Re: 2025/62/91126/E

Erection of two detached dwellings and detached single garage with associated external works (within a Conservation Area); 36 Oxford Road, Dewsbury, WF13 4LL

The Coal Authority response: **Material Consideration**

**Figure 3) Development High Risk Area**

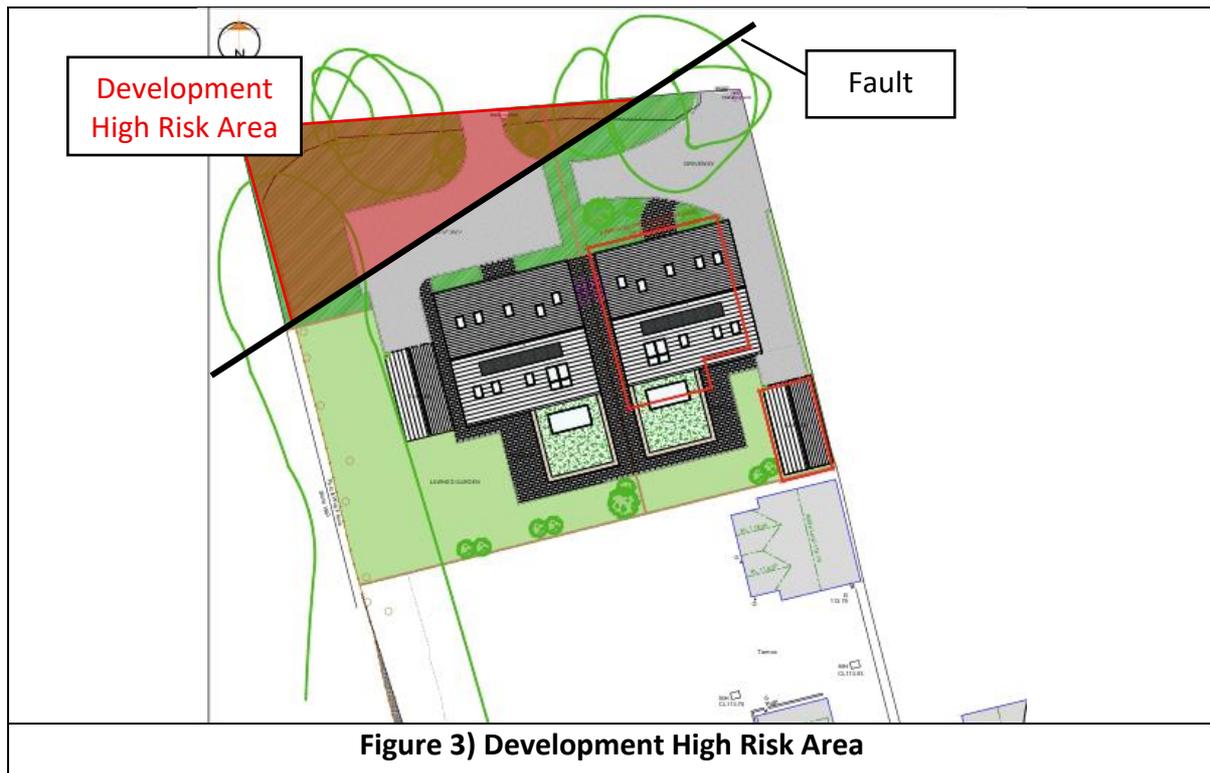
The planning application is accompanied by a Coal Mining Risk Assessment Report (ES03762, 2nd July 2025) prepared for the proposed development by EnviroSolutions Ltd, which concurs with our records. Whilst we acknowledge the Development High Risk illustrated on Figure 3 of the Report, differs to that of our records (which indicate that the area extends further south to that shown on Figure 3), the area where development (where significant groundworks are required) is proposed lies within the Development Low Risk Area only.

Although the development proposed is outside of the defined Development High Risk Area as the site lies within an area where coal mining activity has taken place it is requested that the following wording is included as an Informative Note on any planning permission granted:
